CUMBERLAND COUNTRY GOLF CLUB

Response to DPHI Submission – Summary of Changes

DRAWING TITLE  
**NOMINAL SITE AREA PLAN**

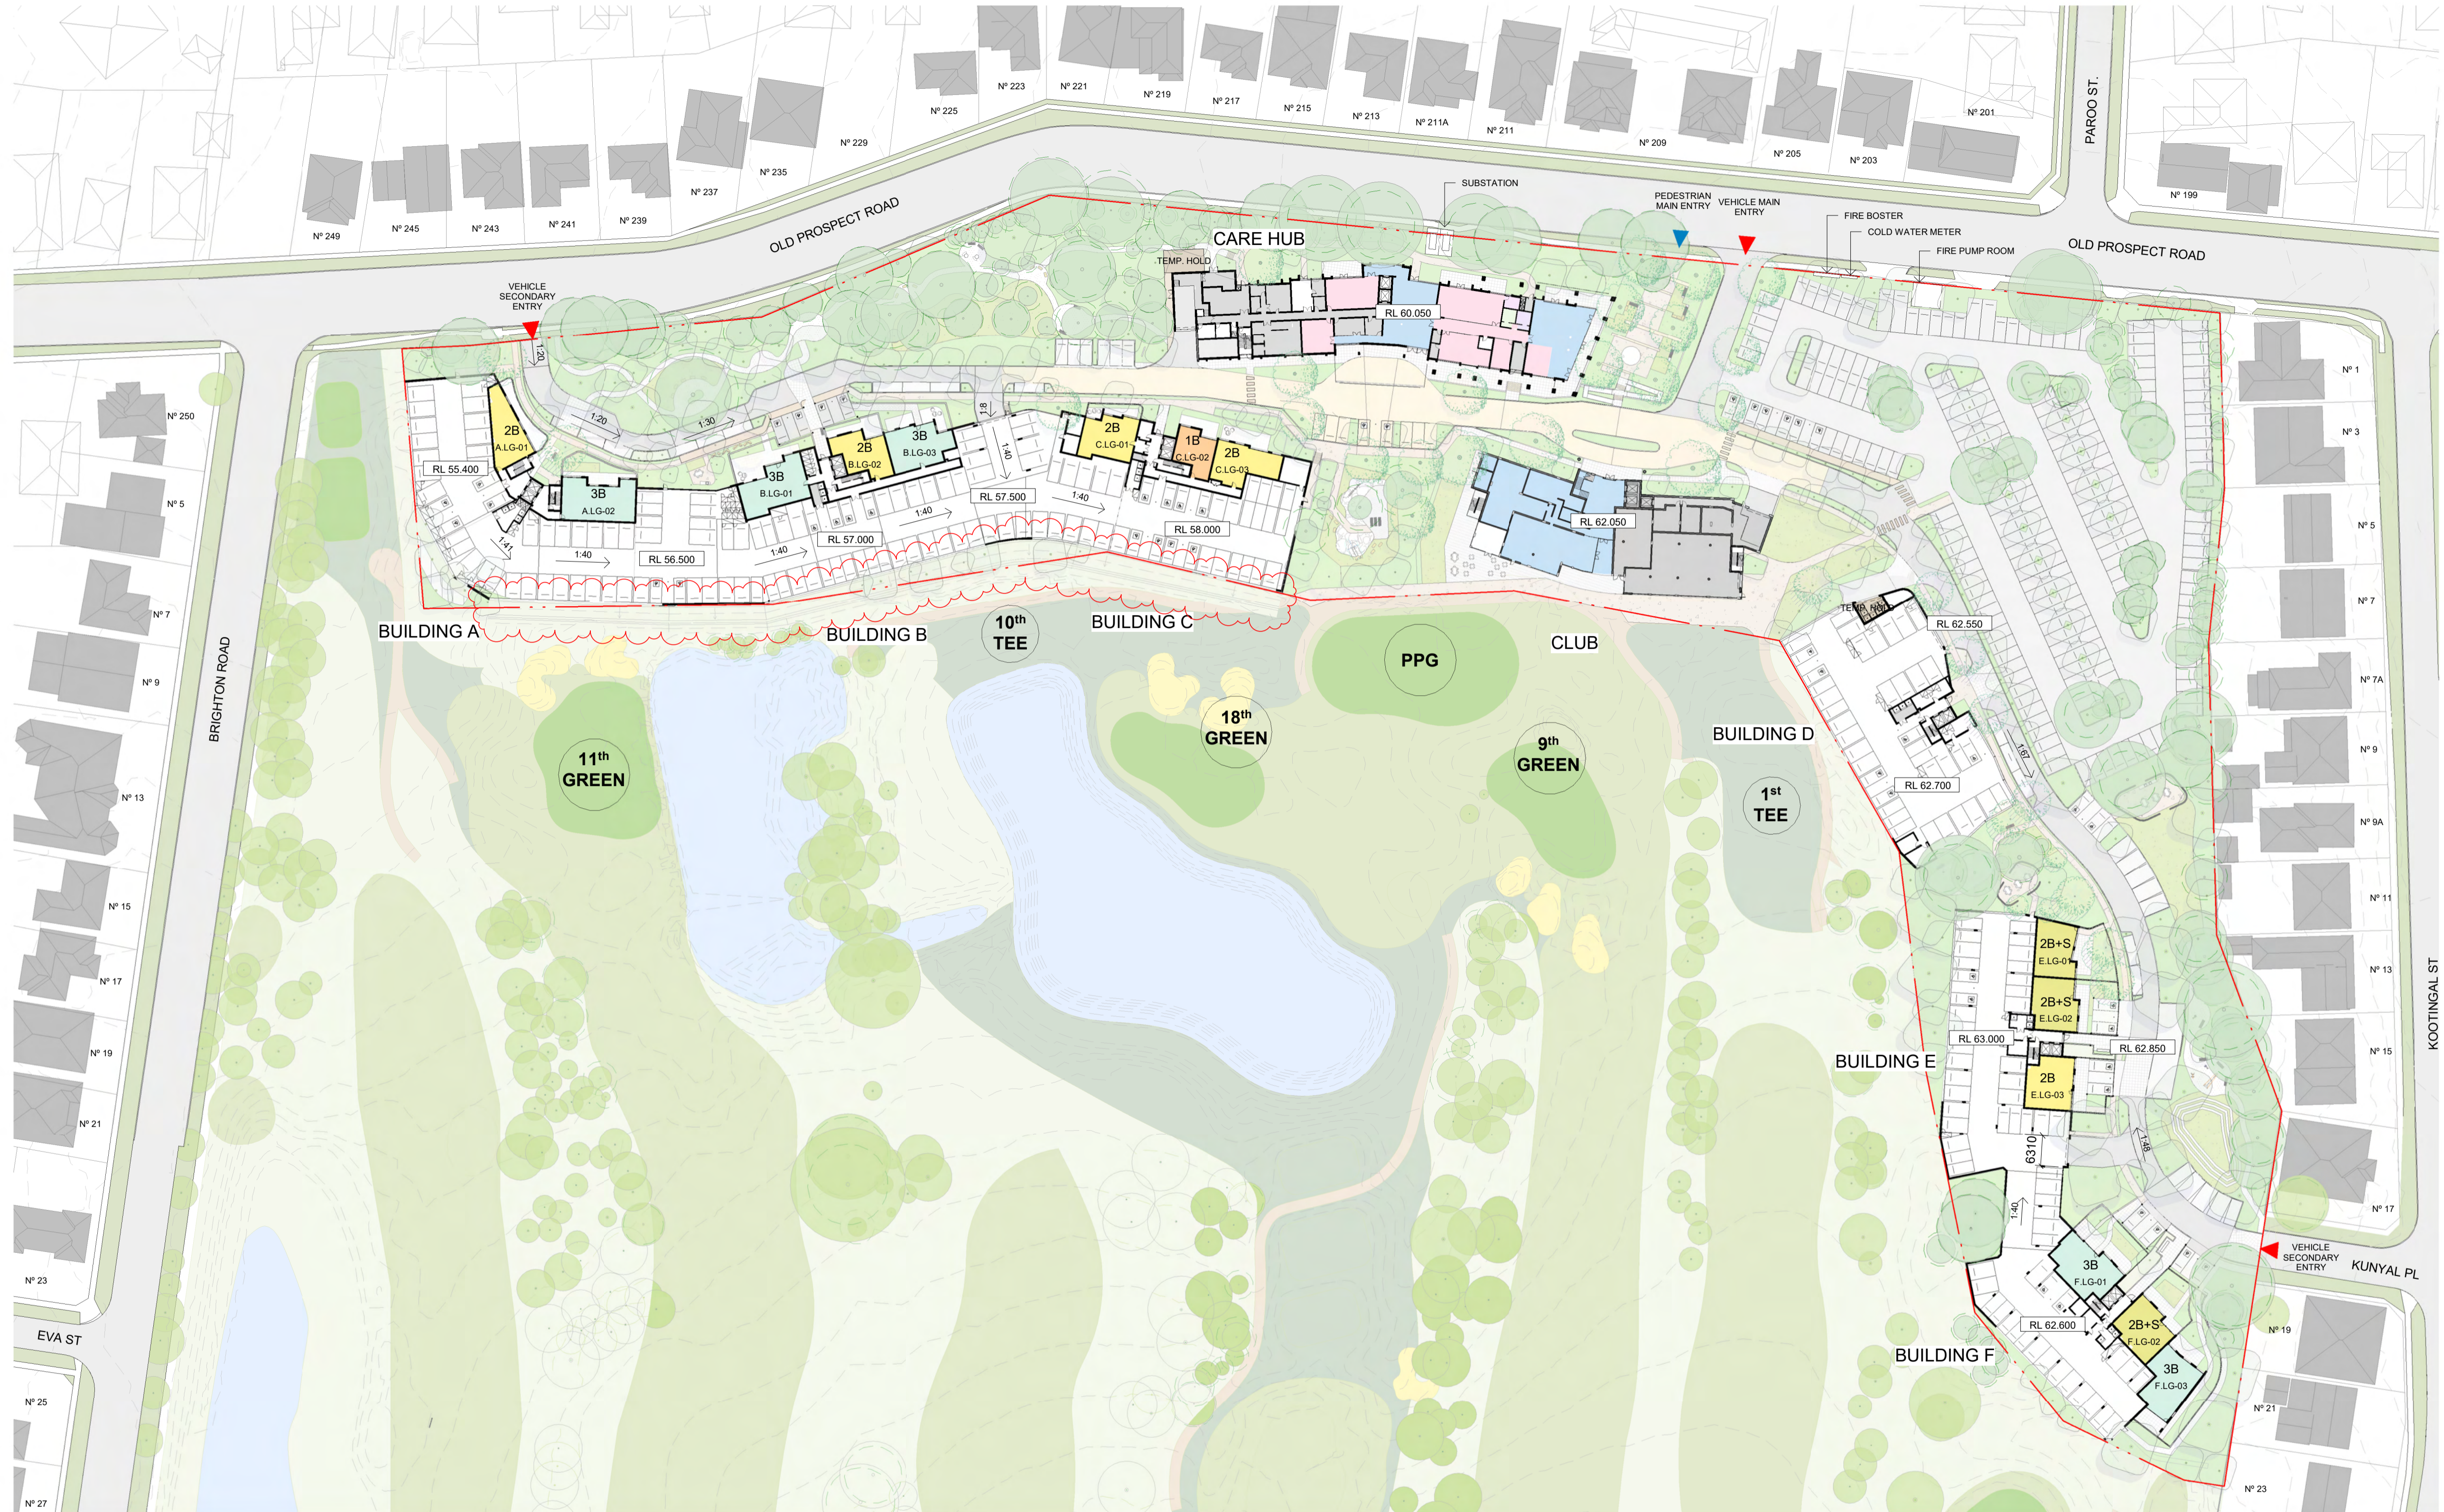
- c. A.3-06: Amended to maintain Unit Mix. Unit converted from 2B to 3B
 - d. F.LG-01 amended to suit redesign and converted from 2B to 3B.
- 8- Nominal Areas Plan: A new drawing DA1.17 has been incorporated into the set, showing the Nominal areas used for FSR and GFA, Deep Soil and Landscaped Areas calculation.

DRAWING TITLE  
**GENERAL FLOORPLAN - LEVEL LOWER GROUND**

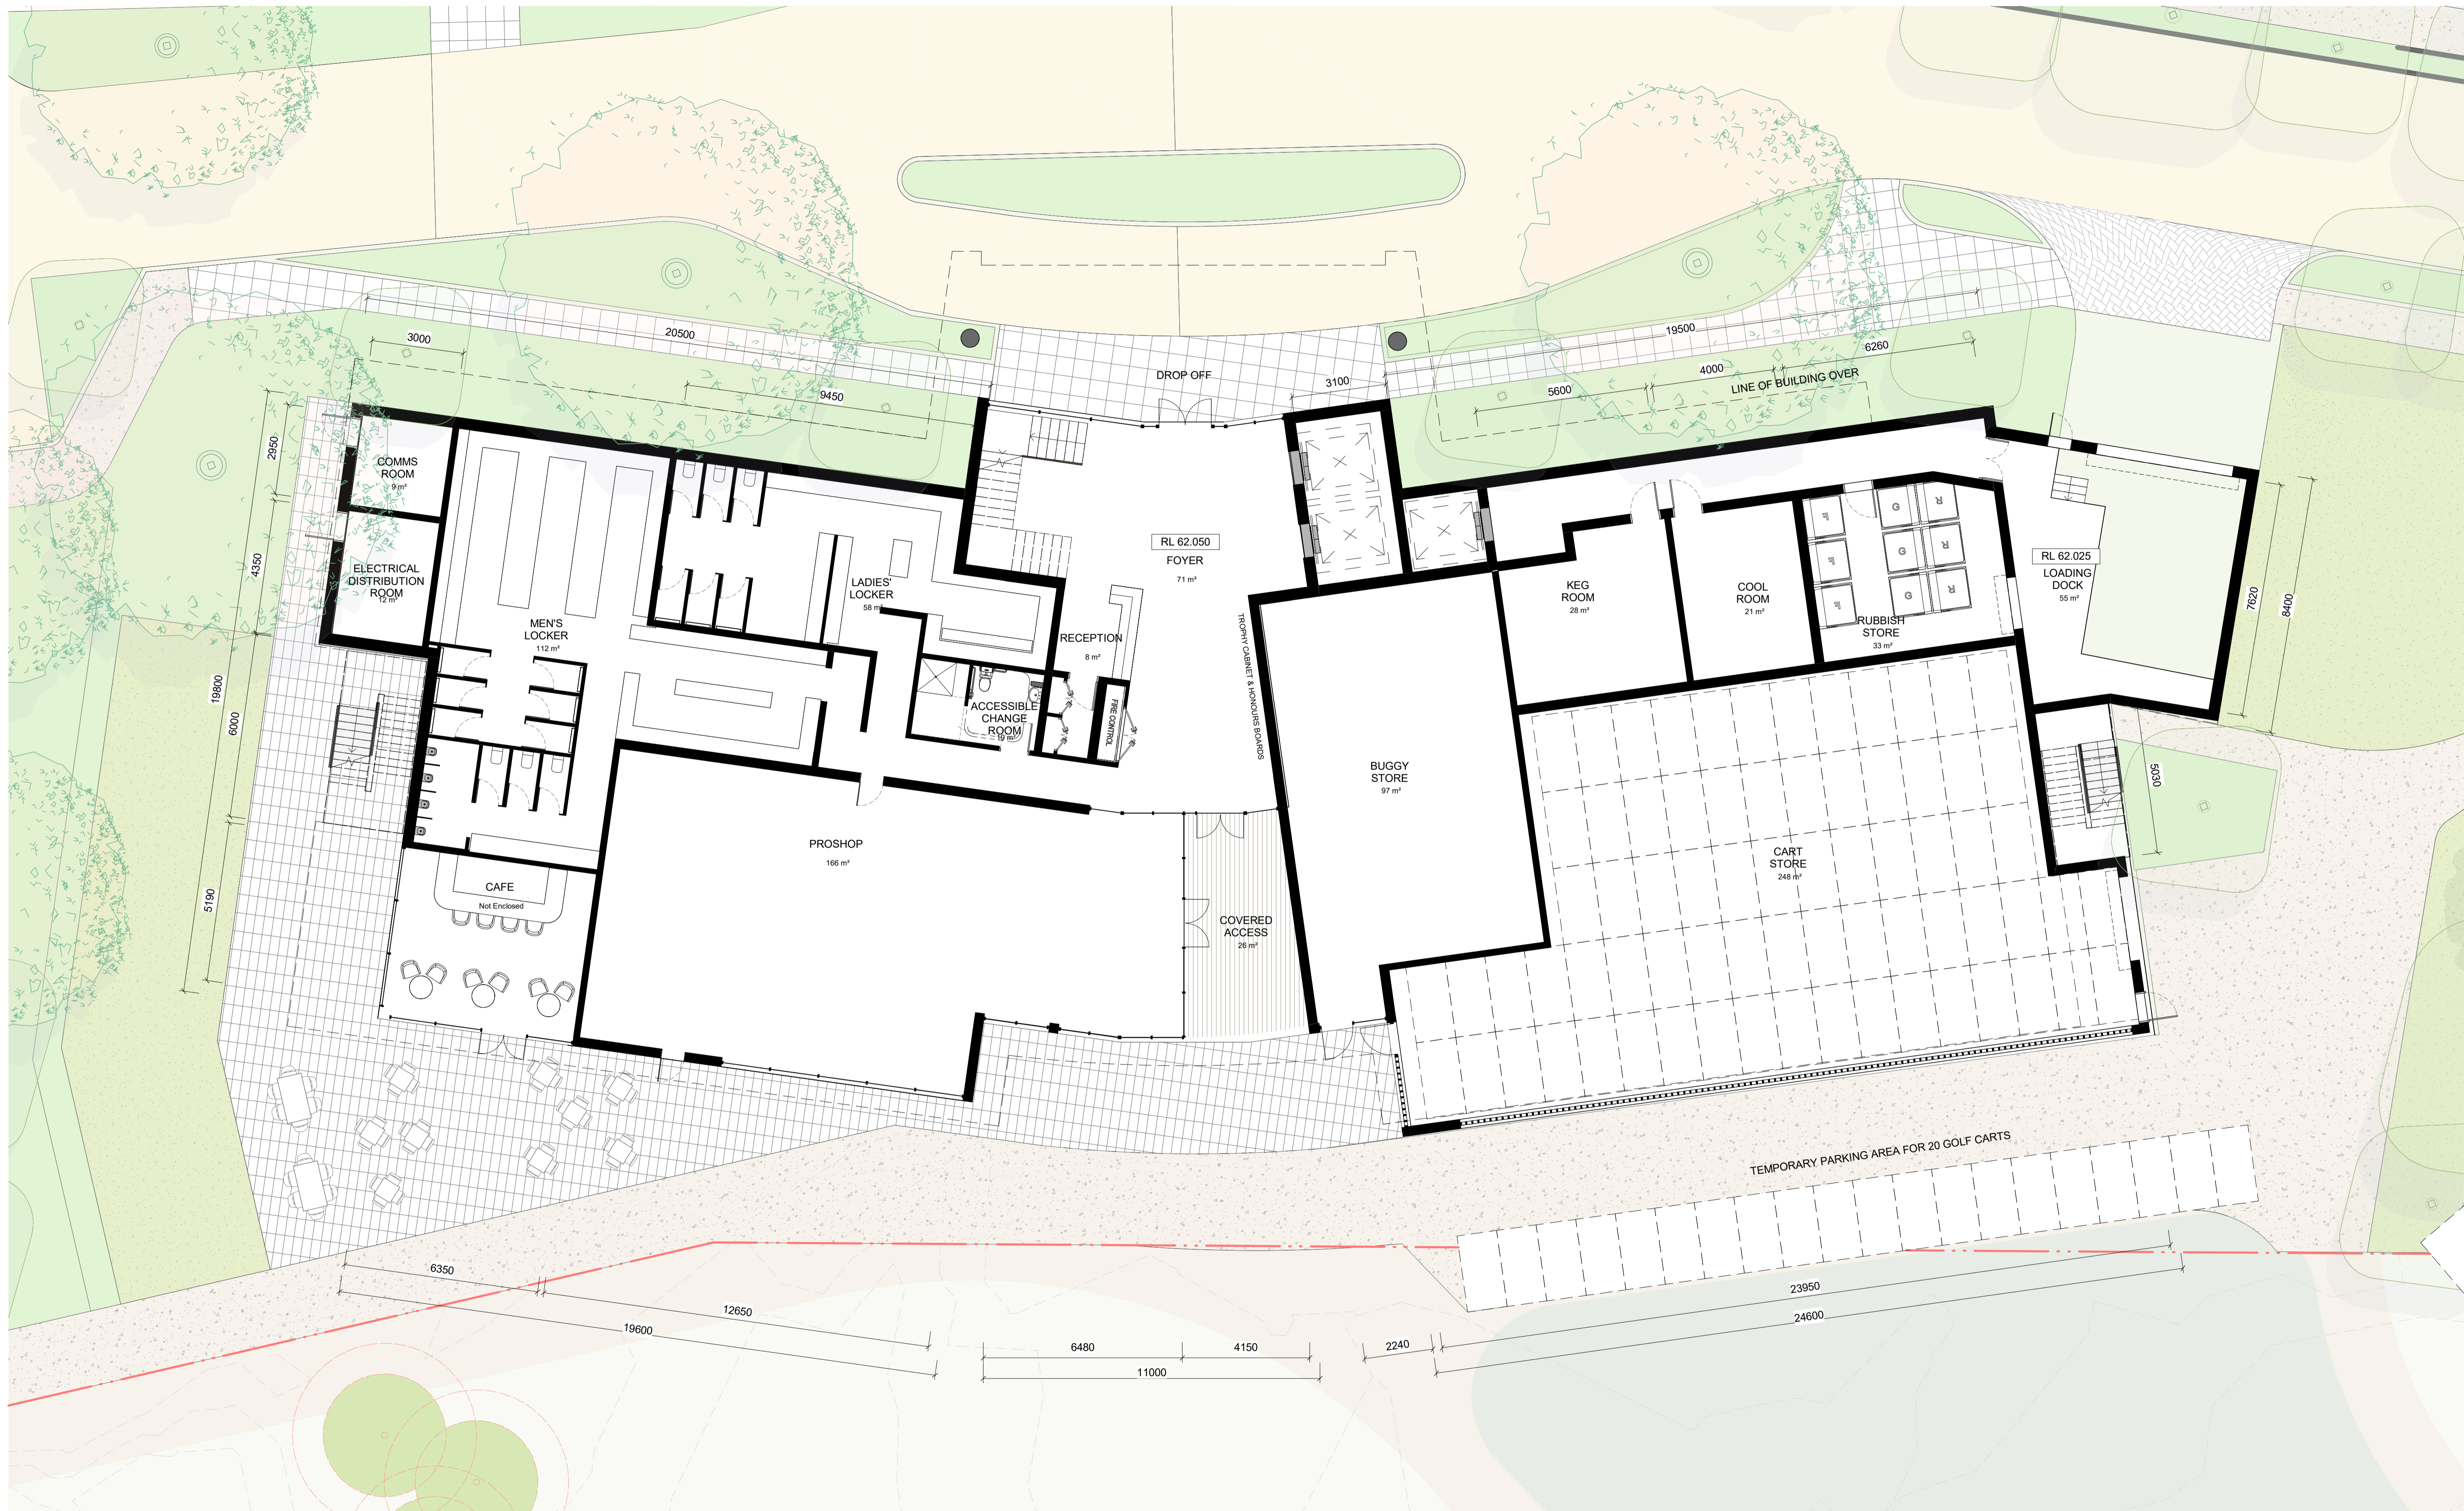
- 6- Lower Ground Parking Areas and Services:
 - a. Building A parking area redesign and extended to the west.
 - b. Building A.1 and A.2 waste rooms unified and relocated adjacent to core lift. Changes to waste chutes and services risers accordingly.

- c. Building A-B vehicular entry removed
 - d. Building A-B parking area extended, and landscape area reduced
 - e. Building B-C vehicular entry added.

- f. Building B-C parking area extended, and landscape area reduced
 - g. Building C external wall modified slightly.
 - h. Building D parking area extended to the south.

- i. Buildings E and F parking area connected.
 - j. Building E vehicular entry relocated and Building F entry removed.
 - k. Lower Ground Storage and Services across all buildings relocated to suit.

DRAWING TITLE  
**SHADOW ANALYSIS - SHEET 1**  
SCALE  
1:2000 @A1  
1:4000 @A3  
JOB  
**20082**  
DATE  
15/11/2024  
DRAWN  
SM  
CHECKED  
MS  
REVISION  
D

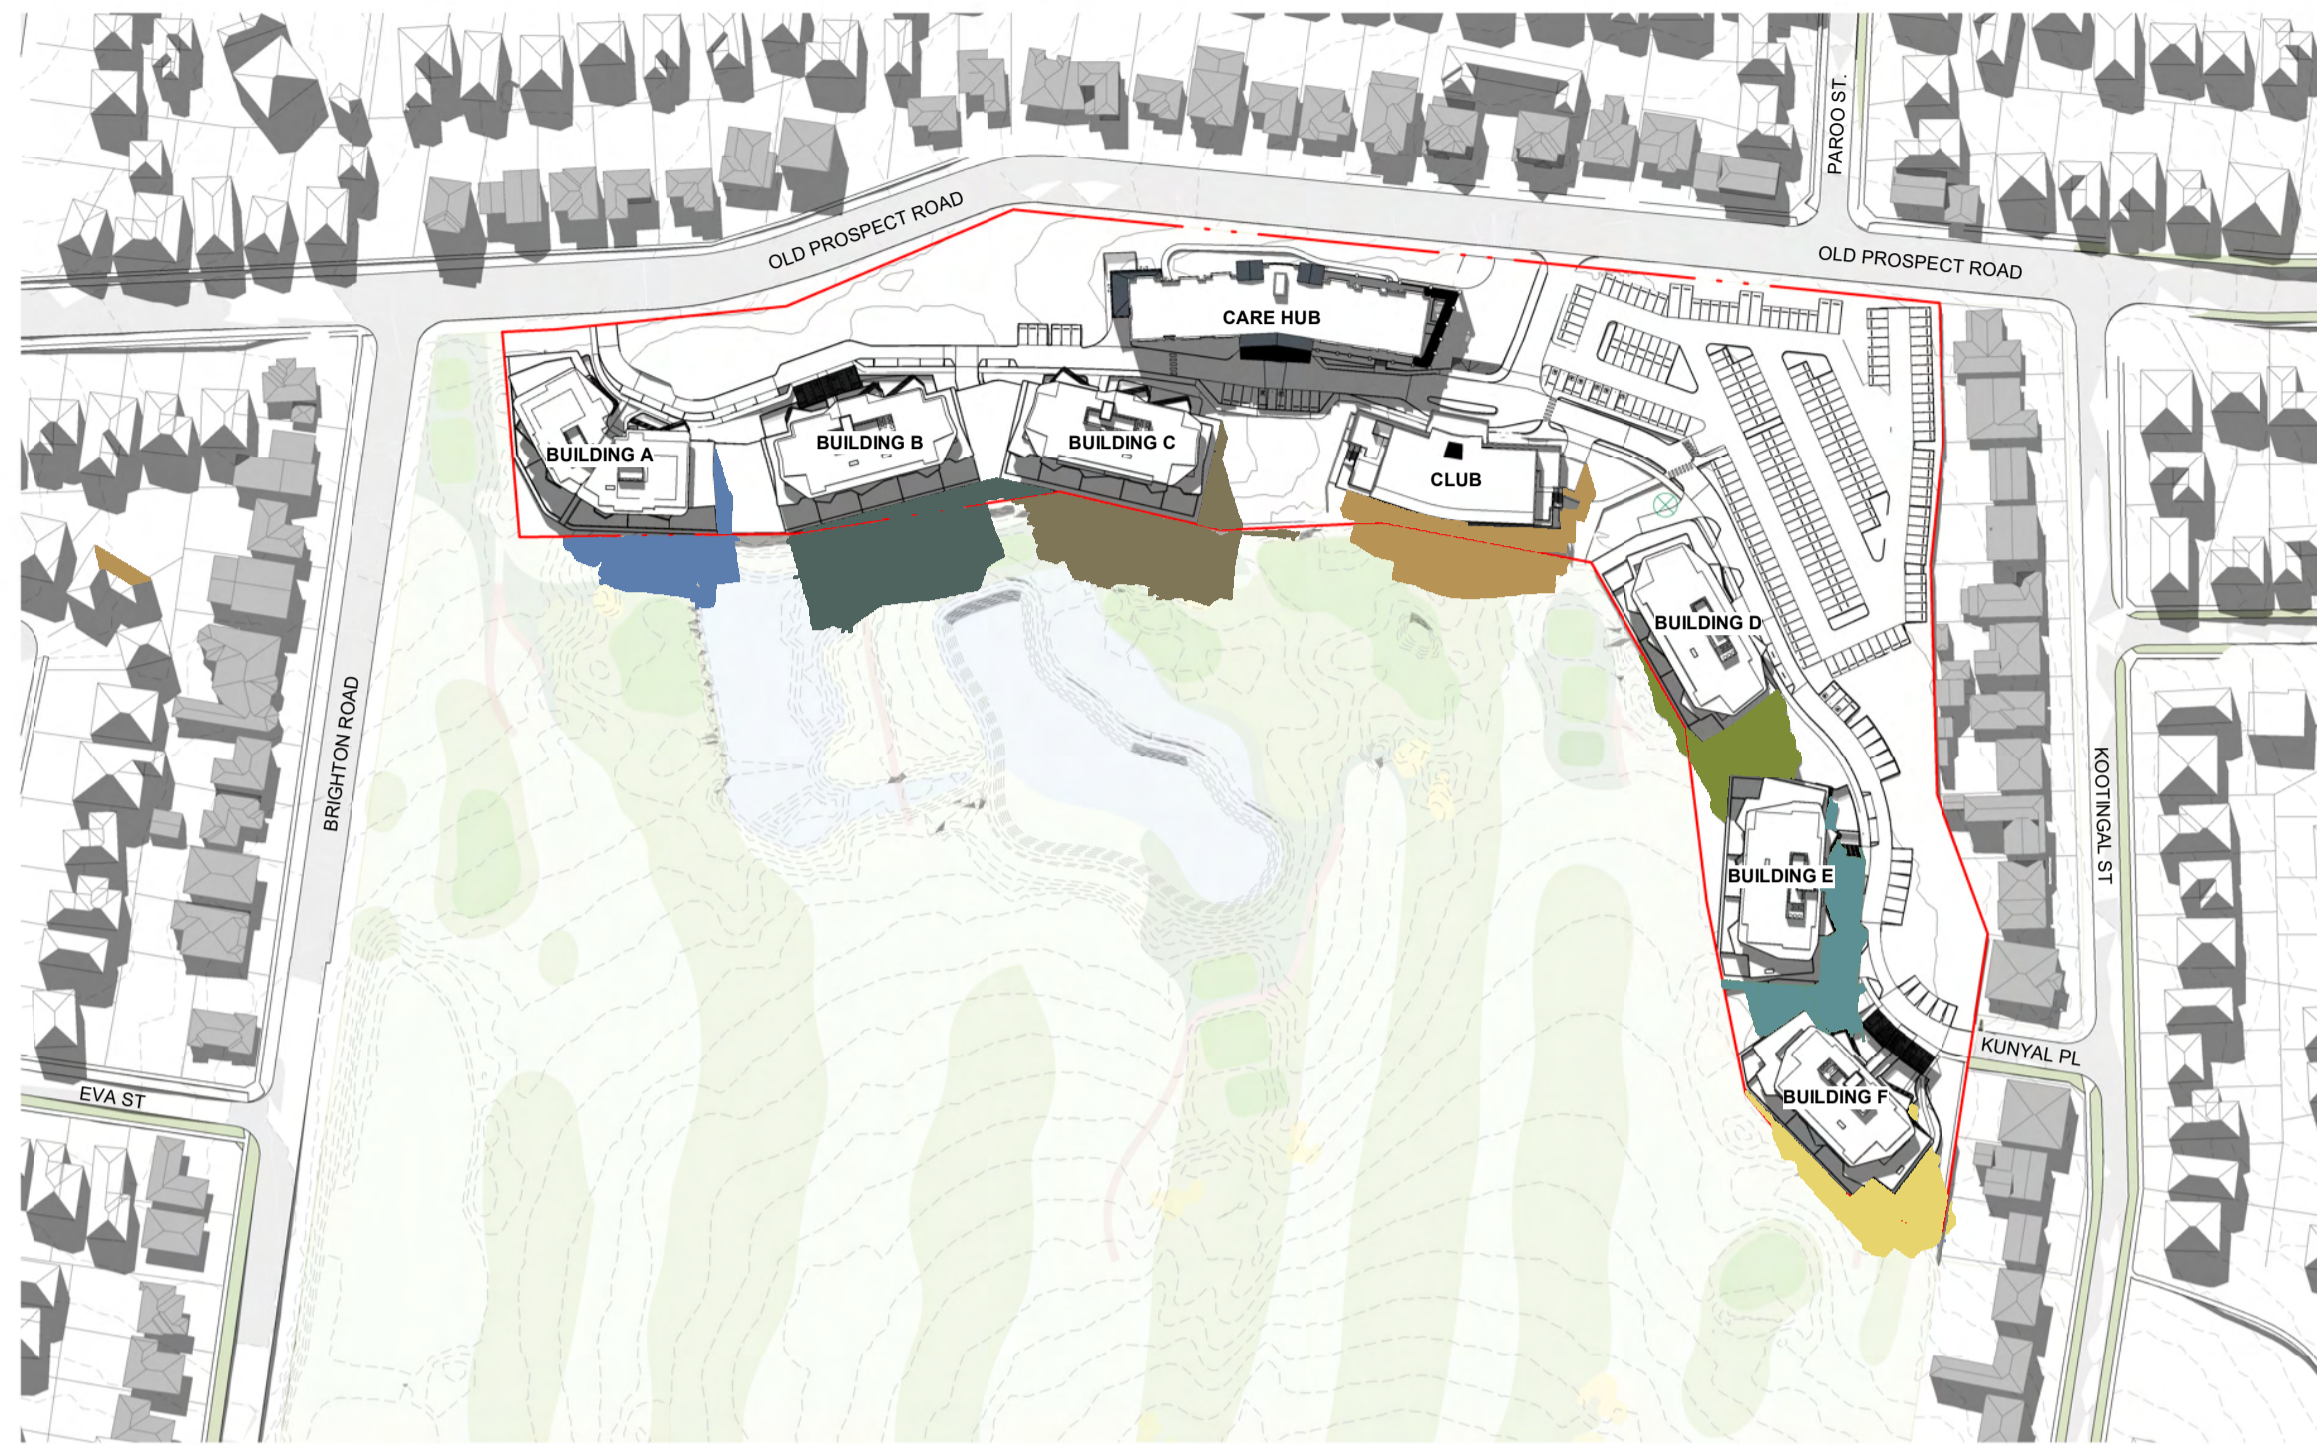
- 9- Shadow Diagrams: Drawings DA7.01 to DA7.03 have been amended to show shadows coloured by building. DA7.03 shows a detailed area of Buildings E and F shadows from 13:00 to 15:00, noting the encroachment area of the shadows into the private open space of neighbouring properties by hour.
